# CITY OF ALBUQUERQUE

March 17, 2021

Re: **Project Name**  
**Project Address**  
**Traffic Circulation Layout**  
Engineer's/Architect's Stamp 03-10-21 (H14-D114)

5 RAMP & SIDEWALK SECTION
1/2"=1'-0"

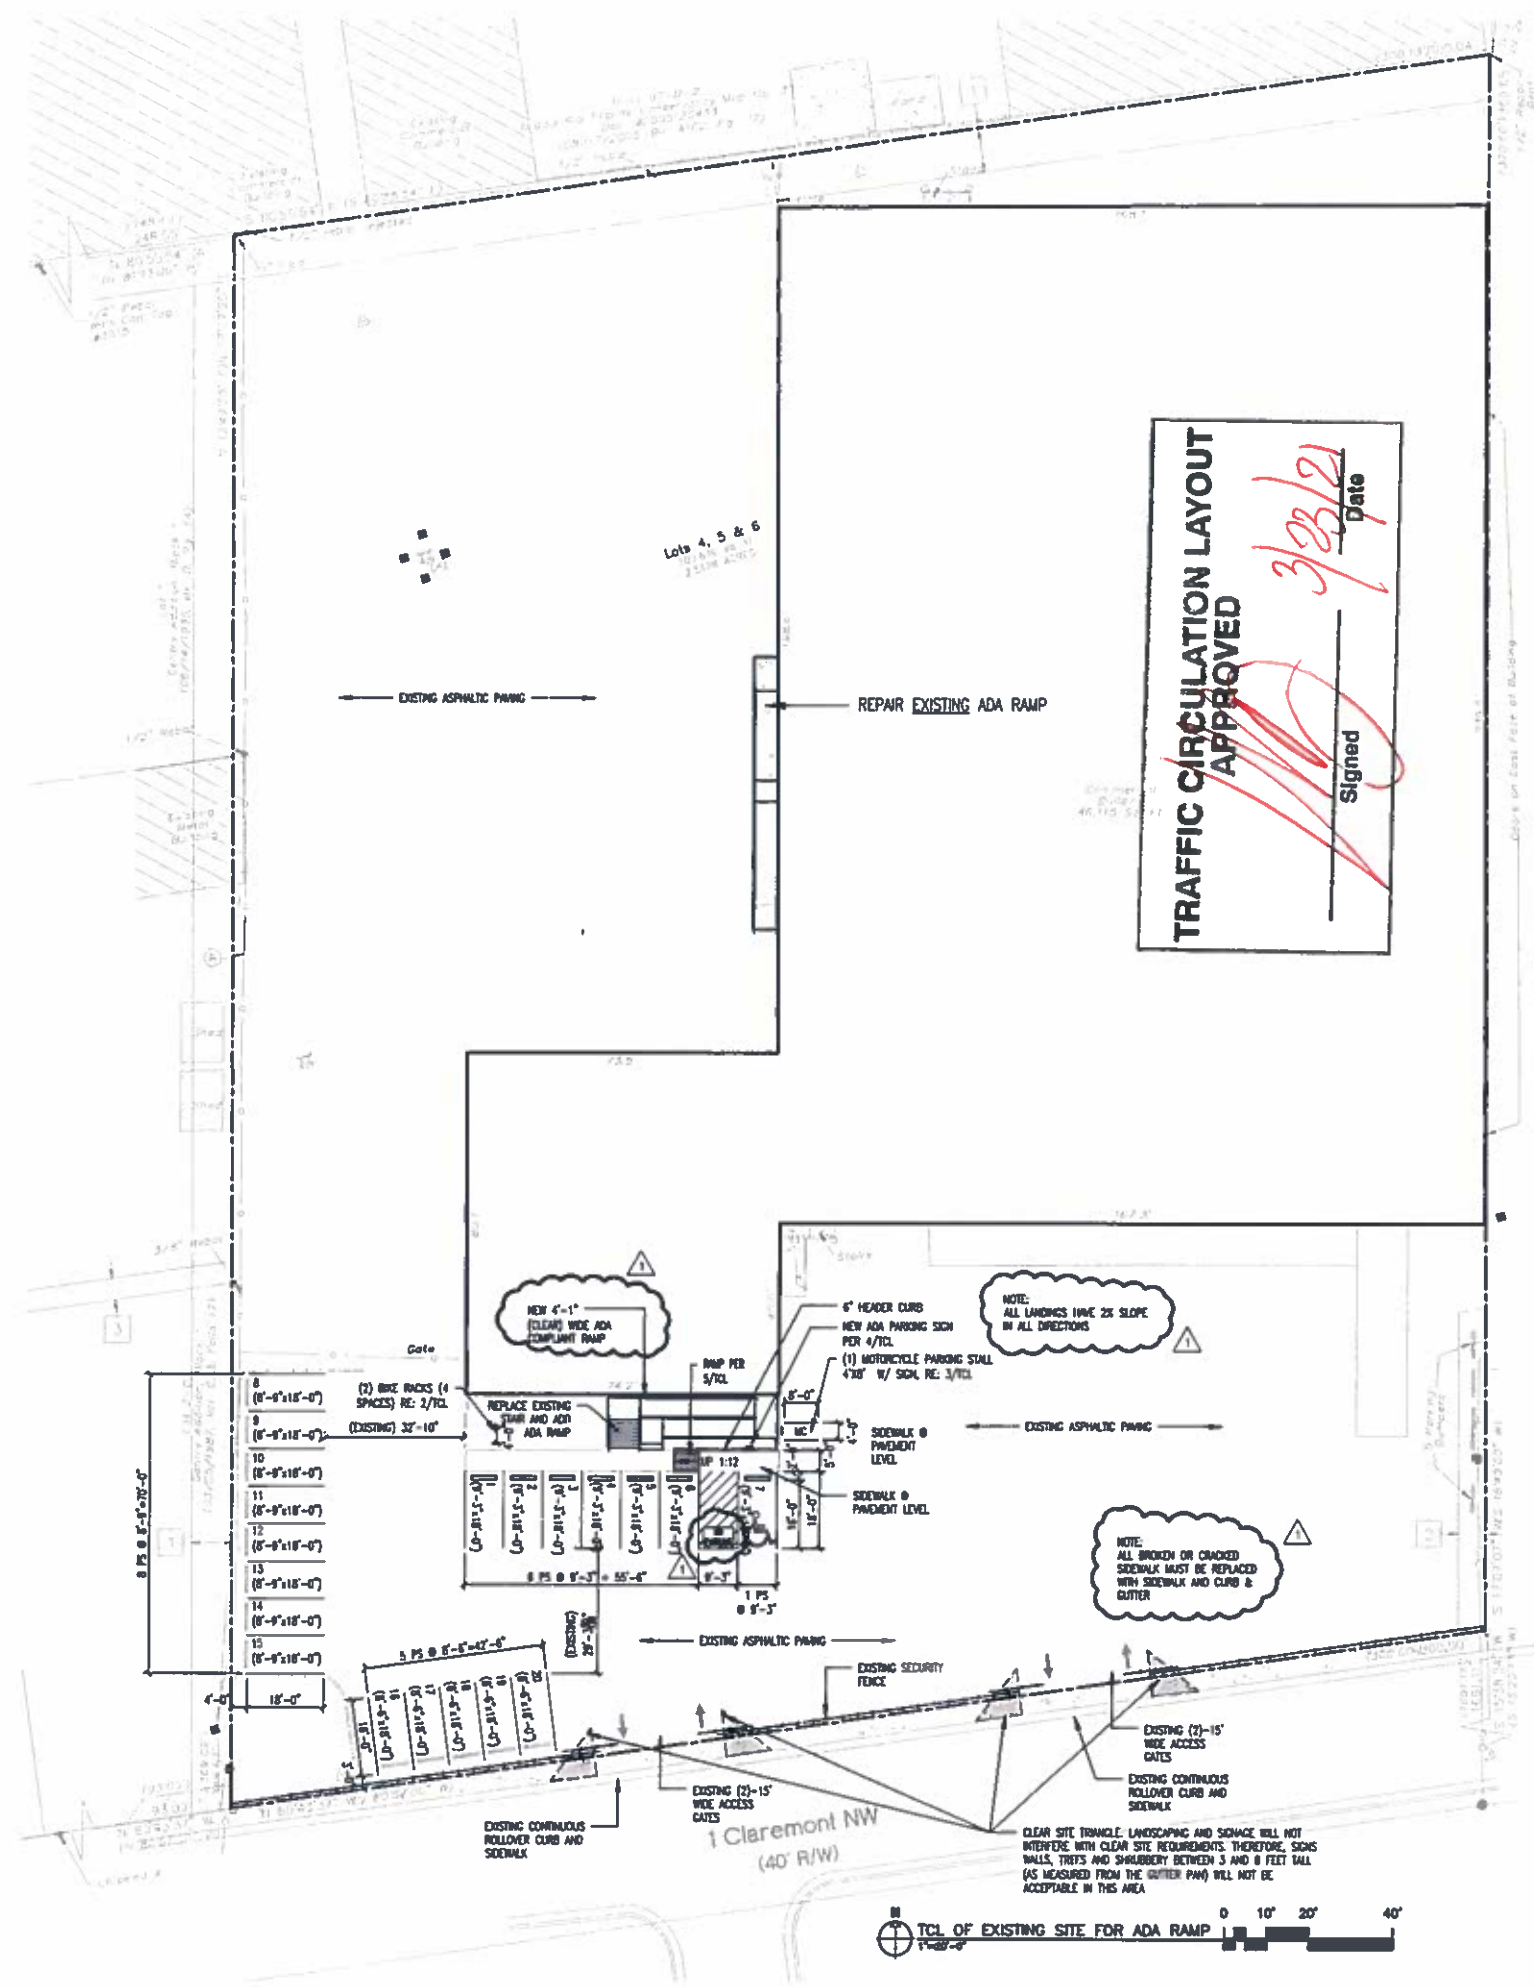
1. Proposed ramps: Landings must have 2% in all directions. Please label them as such.
2. The **ADA access aisles** shall have the words "**NO PARKING**" in capital letters, each of which shall be at least one foot high and at least two inches wide, placed at the rear of the parking space so as to be close to where an adjacent vehicle's rear tire would be placed. (66-1-4.1.B NMSA 1978).

A1 RAMP & SIDEWALK
1/4"=1'-0"

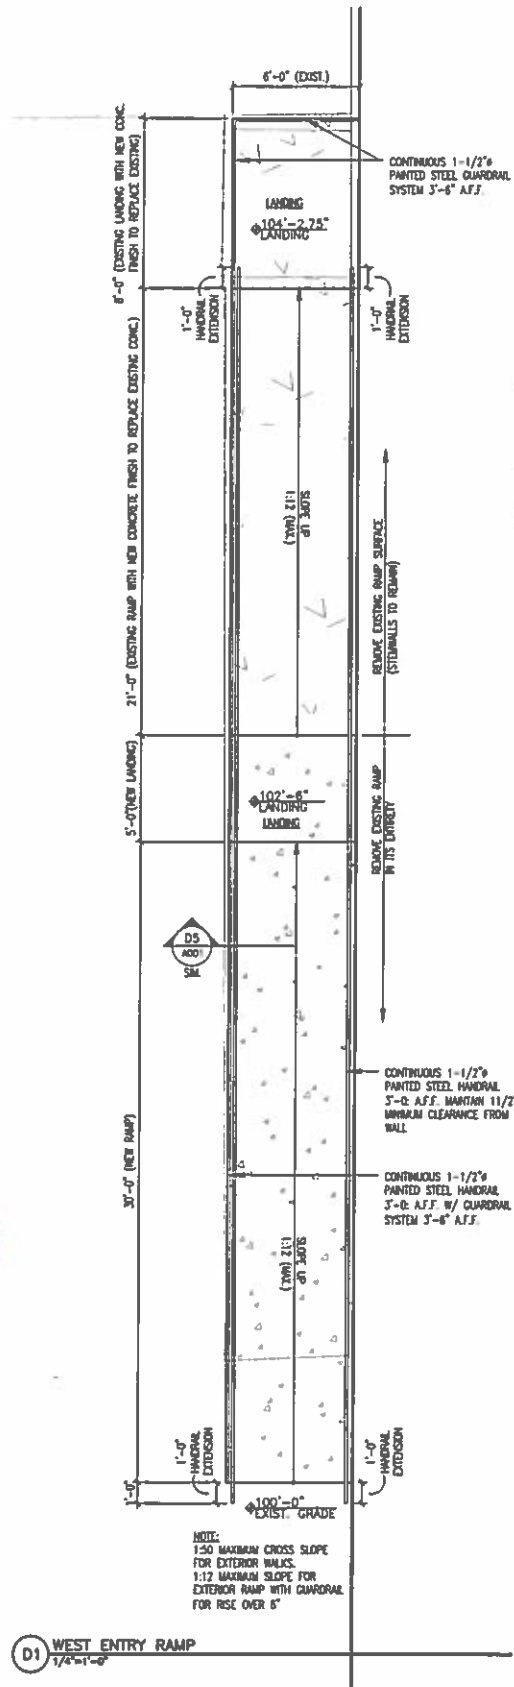
3. Per DPM, a 6 ft. wide ADA accessible pedestrian pathway is required from the ADA parking stall access aisles to the building entrances. Please clearly show this pathway and provide details. **So, your ramp width needs to be 6 ft. wide from the access aisle to the building entrance.**

D1 WEST ENTRY RAMP
1/4"=1'-0"

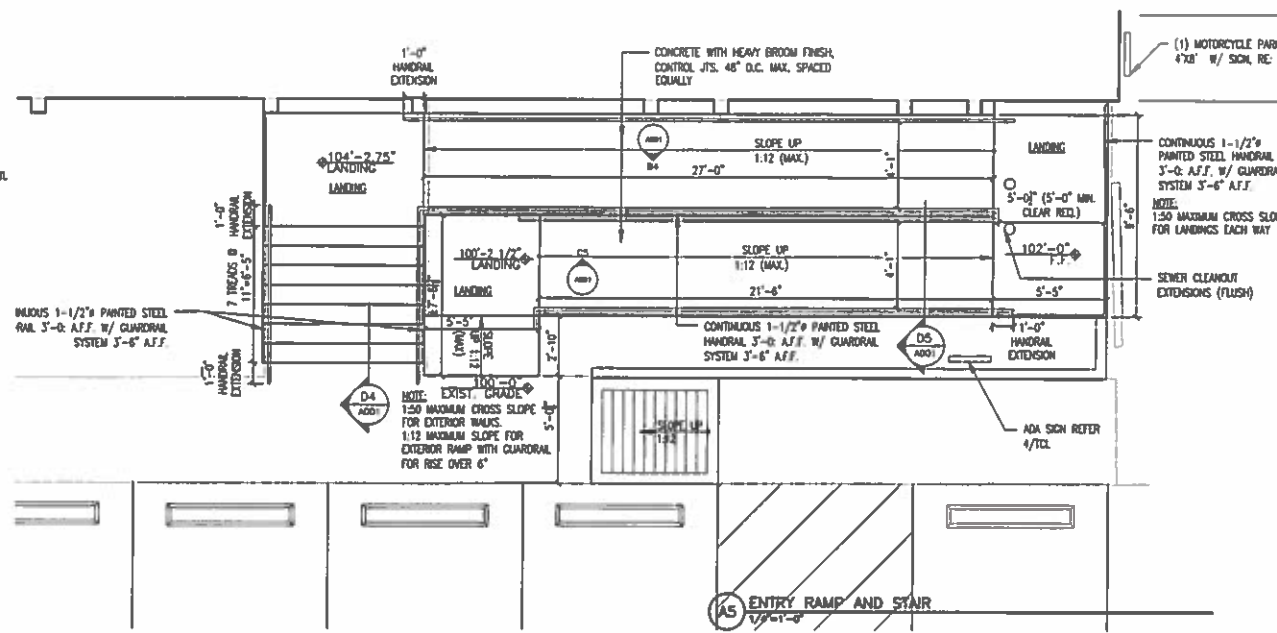
4. Detail D1/A001 & A5/A001: How are you going to attach proposed concrete onto existing entrance concrete? Dowels? Provide details of this concerns.
5. Add a note stating "All broken or cracked sidewalk must be replaced with sidewalk and curb & gutter." A build note must be provided referring to the appropriate City Standard drawing numbers 2430 & 2415.
